From: Laura Gibbons
Sent: 23 July 2018 11:19
To: Planning.Responses
Subject: RE: Planning Consultation on: Y/49/18/PL

Engineers Comments Relating to Surface Water Drainage

APPLICATION Y/49/18/PL

Site Address: Land East of North End Road Yapton

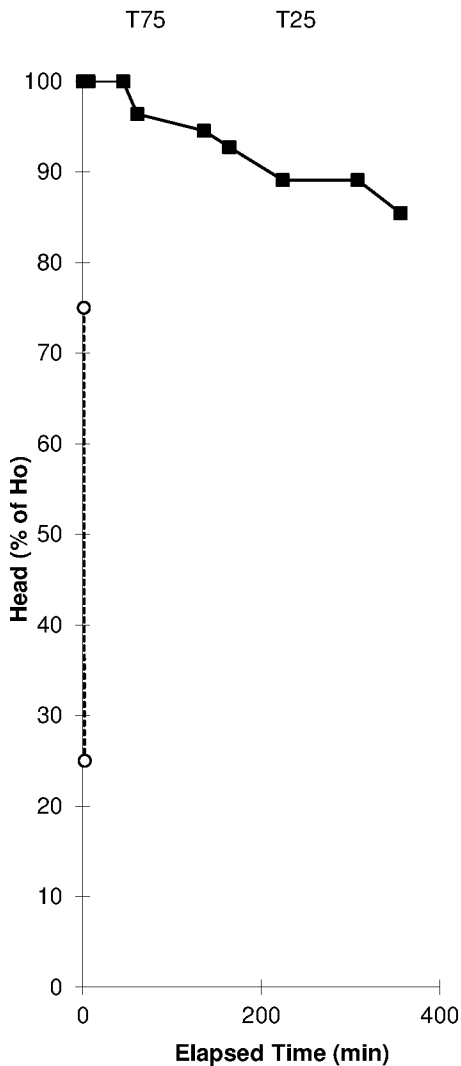
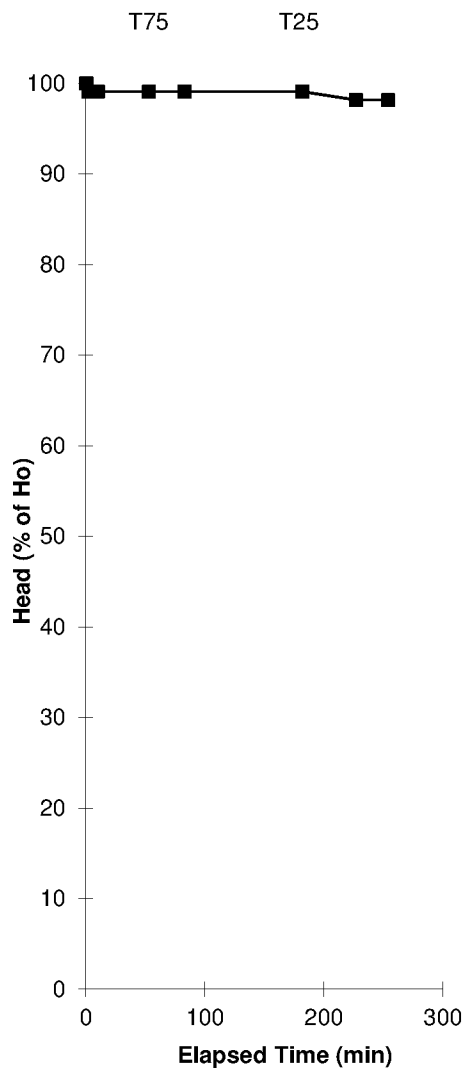
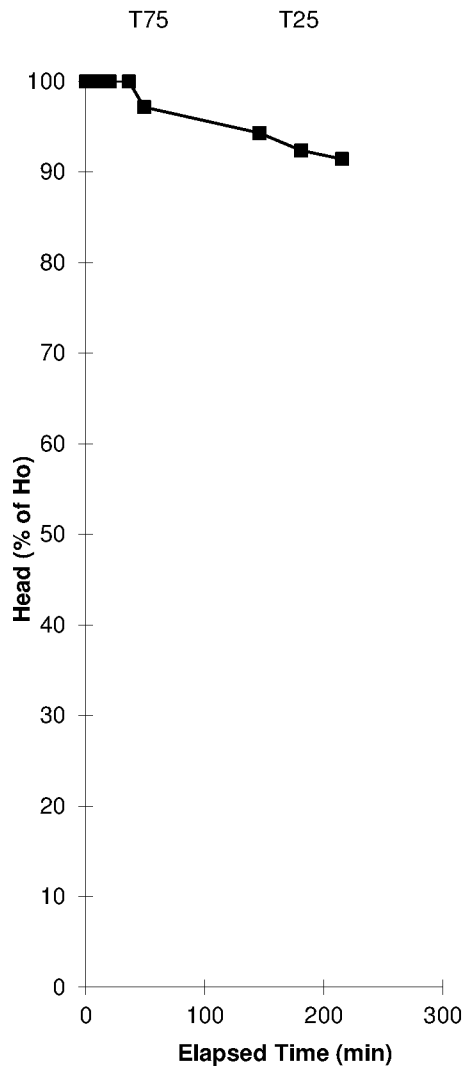
The proposed surface water drainage strategy states that soakaways will be used. However, the infiltration test results given are very low, I suspect this is due to the tests being completed at too great a depth. We will require winter groundwater monitoring to be completed between October and March inclusive and winter infiltration testing to be completed at appropriate depths based on this. I.e. infiltration tests completed above maximum recorded winter groundwater levels, and at proposed depths of soakaways.

Infiltration rates for soakage structures are to be based on percolation tests undertaken in the winter period and at the location and depth of the proposed structures. The percolation tests must be carried out in accordance with BRE 365, CIRIA R156 or a similar approved method and cater for the 1 in 10 year storm between the invert of the entry pipe to the soakaway, and the base of the structure. It must also have provision to ensure that there is capacity in the system to contain below ground level the 1 in 100 year event plus 40% on stored volumes, as an allowance for climate change. Adequate freeboard must be provided between the base of the soakaway structure and the highest recorded annual groundwater level identified in that location.
